Recommendation Report for Planning Permission

REF NO: FP/84/22/PL

LOCATION: 7 Ambleside Close
Felpham
PO22 8NG

PROPOSAL: Erection of 1 No three-bed detached dwelling (resubmission of FP/86/21/PL). This site is in CIL Zone 4 and is CIL Liable as a new dwelling.

PROPOSED SITE PLAN
SCALE: 1:100 @ A1

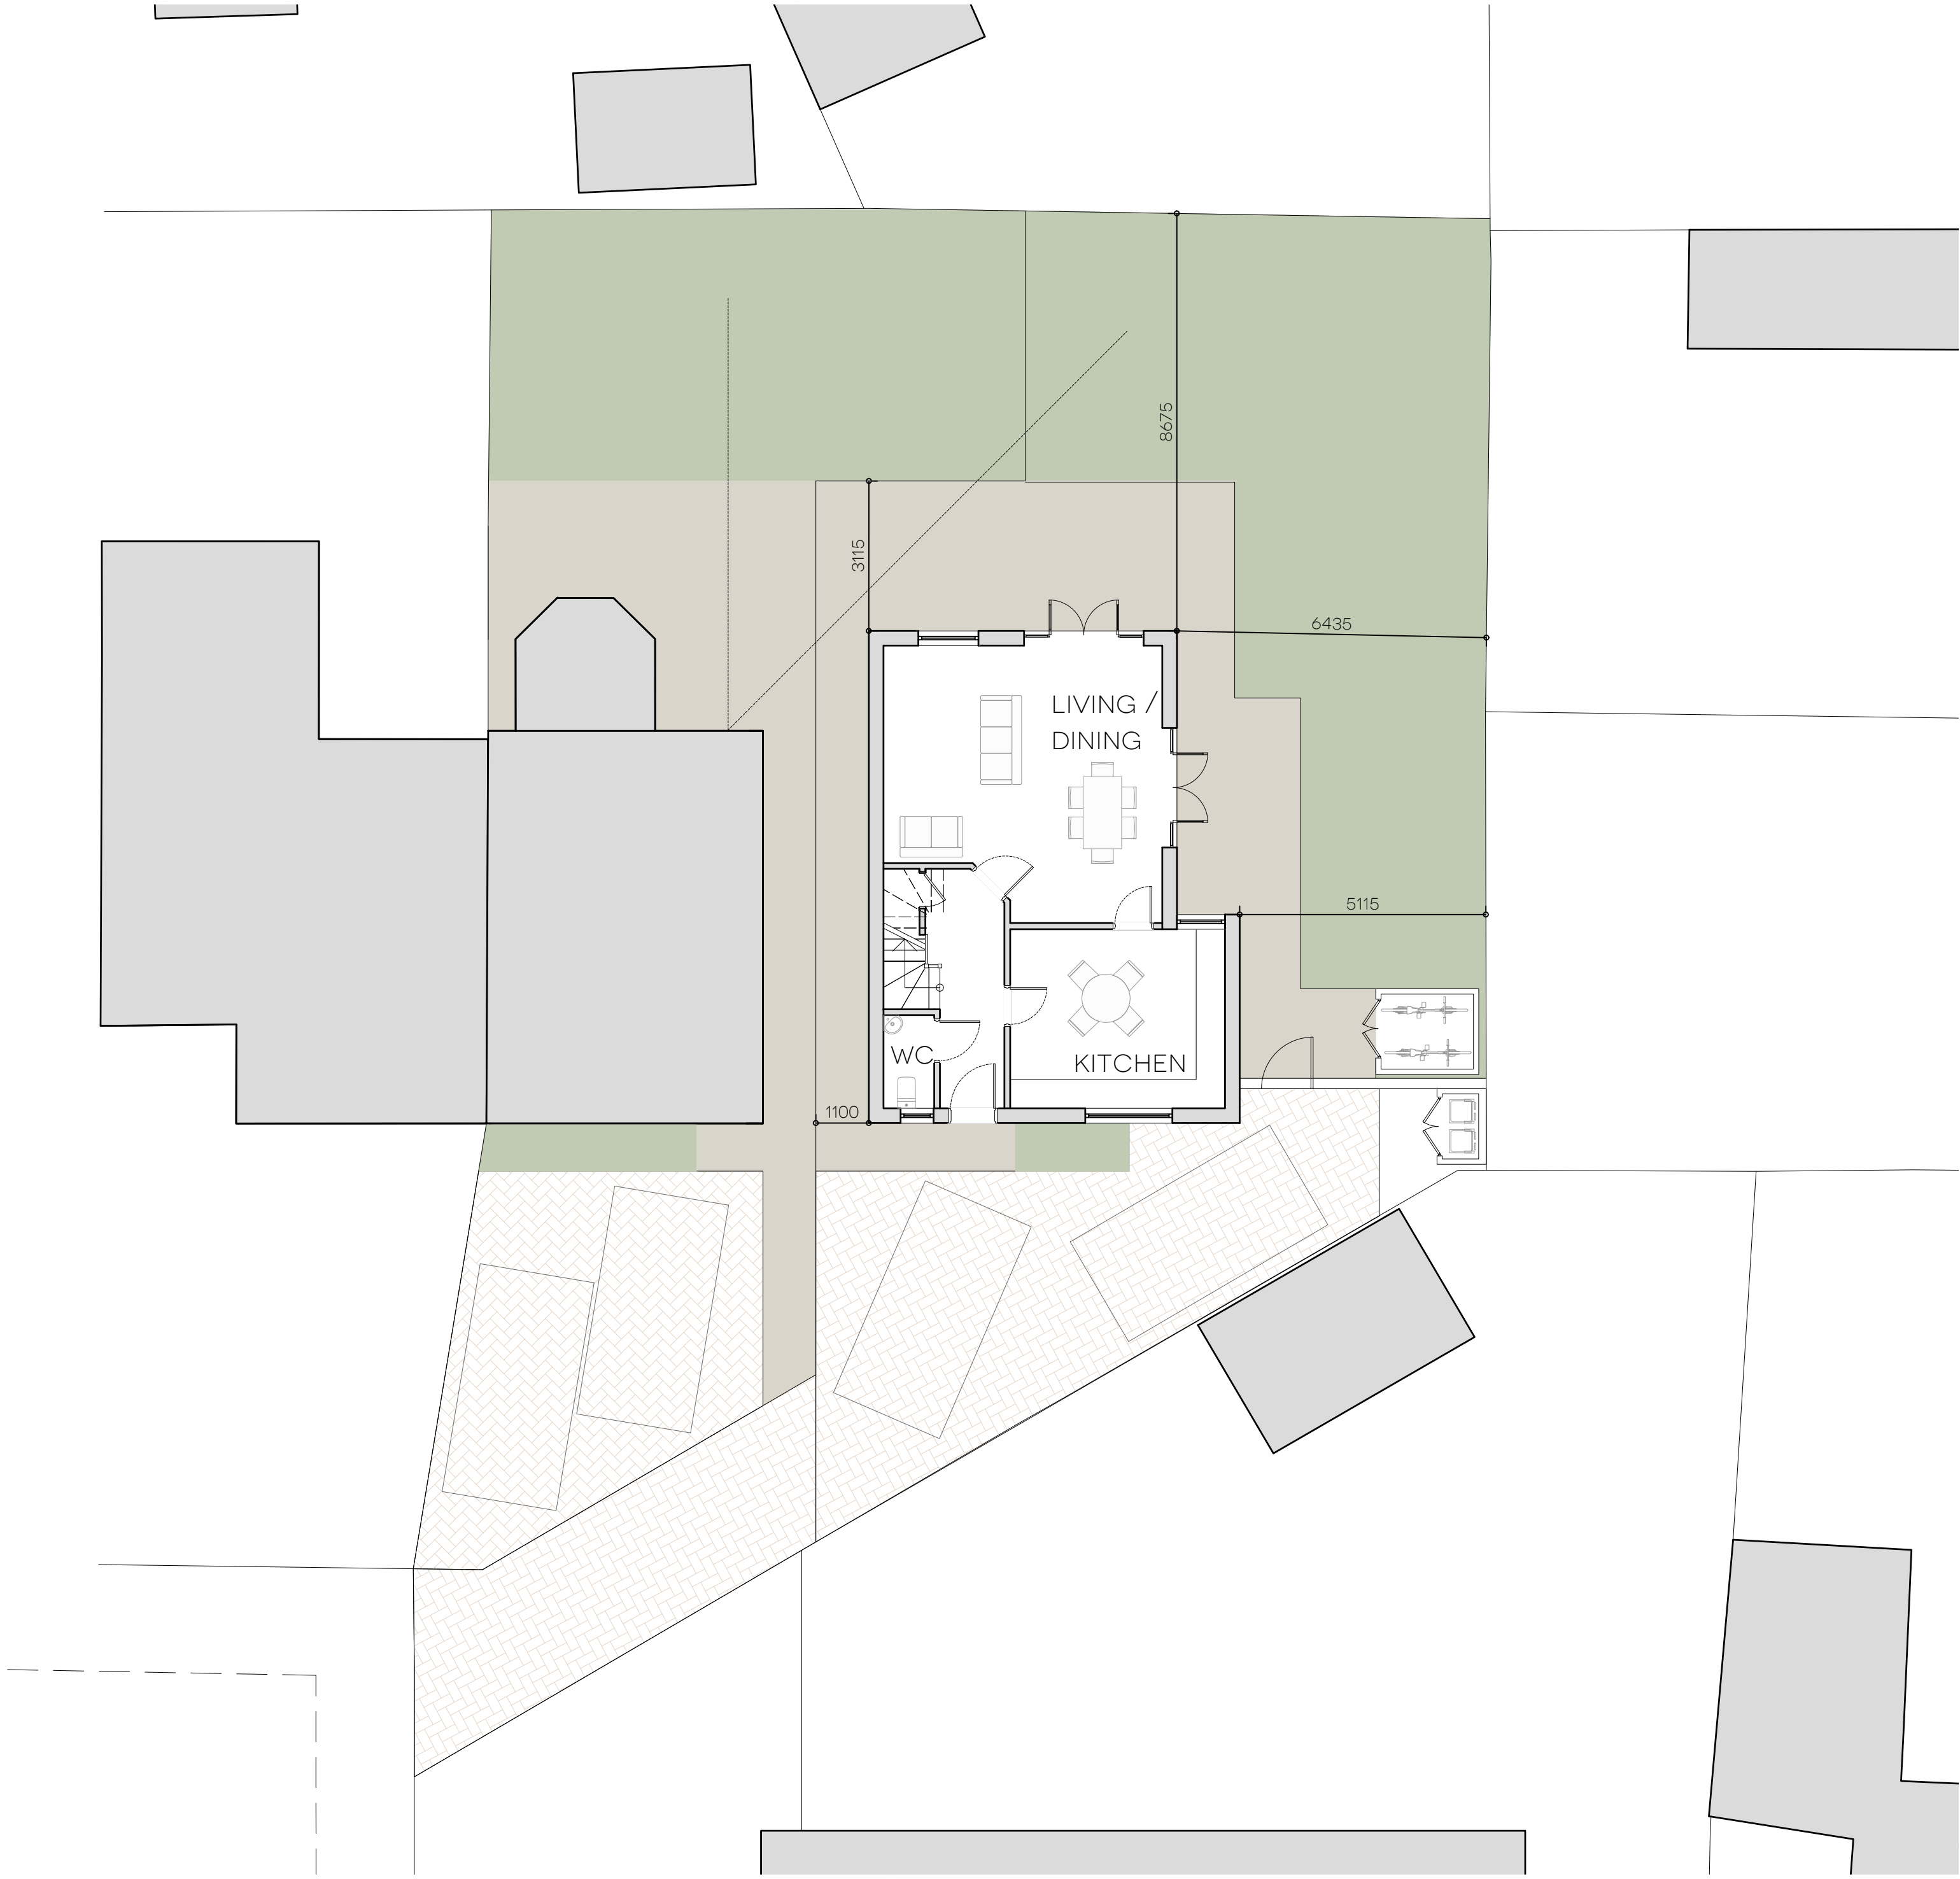
The gabled roof dwelling would be within 2.1m from the flank elevation of host property, 5m to 6.4m from the shared boundary with 3 and 5 Thirlmere Way. The current proposal would be 1.31m wider than that previously refused, 7.7m wide to the front and 6.4m to the rear, would be 8.87m deep with 1.4m deep single storey rear projection and would be 7.65m high. First floor bedroom window of the front elevation would be omitted, one large casement window, entrance door and a narrow bathroom window with a canopy above are proposed at the ground floor level and a triple casement bathroom window at the first-floor level of the front elevation. French doors with side windows are proposed on the south-eastern and the north-eastern elevation. One narrow, obscure glazed window would be inserted on the north-western elevation. There would be 3 casement windows at the first-floor level and 2 casement windows at the ground floor level of the north-eastern elevation.

The south-western (front elevation) would be within a separation distance of 5m from the shared boundary with No 8 Ambleside Close and would face to side elevation of this property with the most private amenity space due to the lack of a significant rear garden. This arrangement would result in an uncomfortable relationship between the proposed and existing. The proposed first floor windows on the north-eastern elevation serving bedrooms would directly overlook the rear garden of host property and the garden of No 7 Thirlmere Way.

The drawings show an area dedicated to residential outdoor amenity; the area of rear garden would satisfy the requirement of the Arun Design Guide; however, the resultant rear garden of the host property would be exposed to the direct overlooking from the first-floor windows of the proposed dwelling.

PROPOSED FIRST FLOOR PLAN
SCALE: 1:50 @ A1

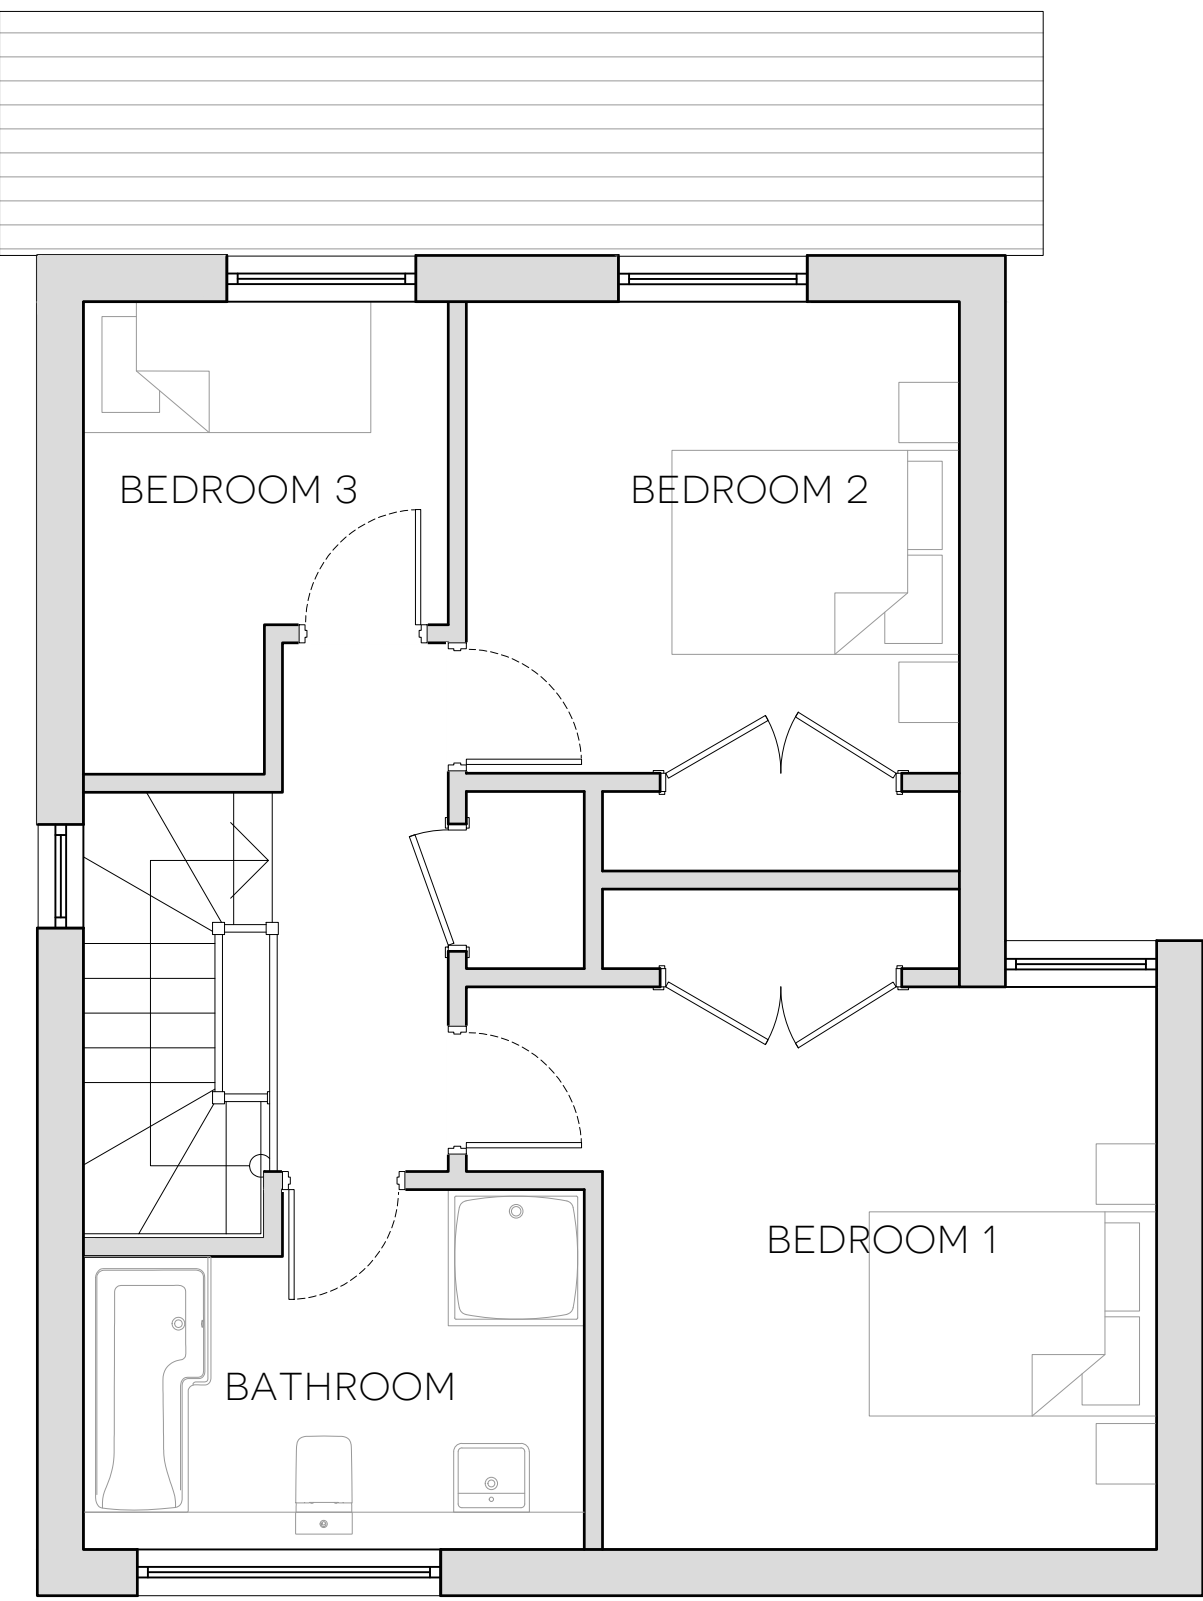
requirement for a 3-bed dwelling size (102 sqm for 3 bed/5persons, 2 storey dwellings). Nationally Described Space Standards require a single bedroom has a floor area of at least 7.5m² whilst bedroom 3 would have 6.3sqm only.
